From: Simon Davis
Sent: 26 October 2017 10:56
To: Planning.Responses
Subject: FP/175/17/L – The Whyke House, 47 Felpham Way

Conservation Officer Response

FP/175/17/L – The Whyke House, 47 Felpham Way – LBC to add secondary glazing to 10 windows.

EXISTING & PROPOSED ELEVATIONS

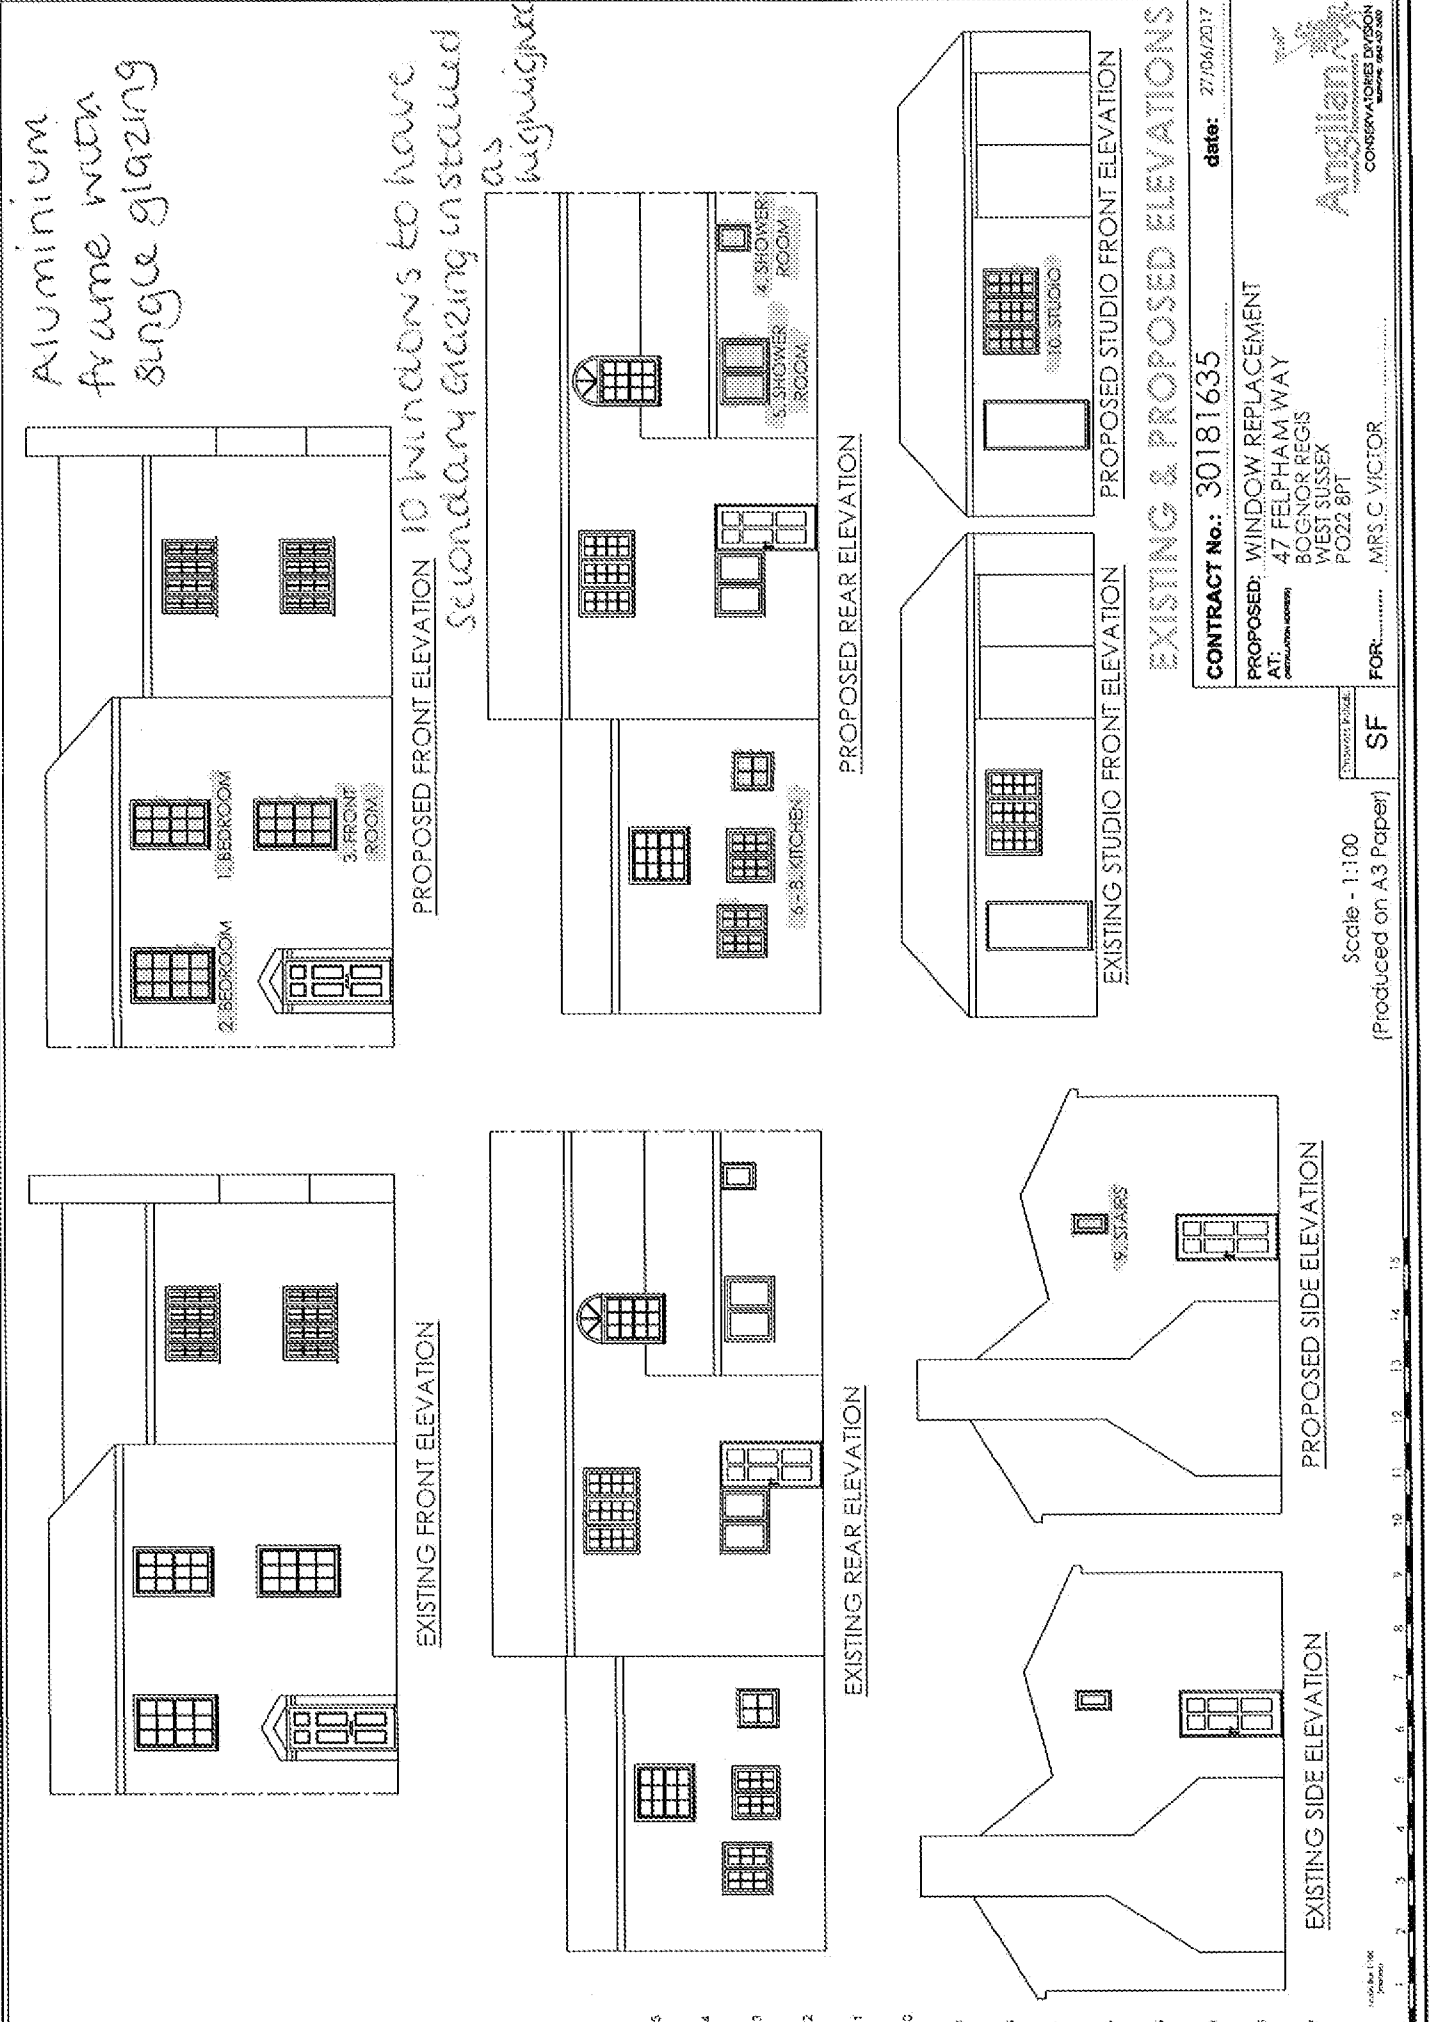
Generally, I'd say no to this, as secondary double glazing is as intrusive visually as double-glazing. That is to say there are two layers of reflectivity which inevitably has an adverse effect on the appearance of the property as a whole. In this case, secondary glazing would also encroach on the historic timber window reveals (and possibly shutters – although they have not photographed all windows). In addition to this, the submitted photographs (towards the end of the application), show secondary glazing already in situ. This appears to be unauthorised, and should be removed.
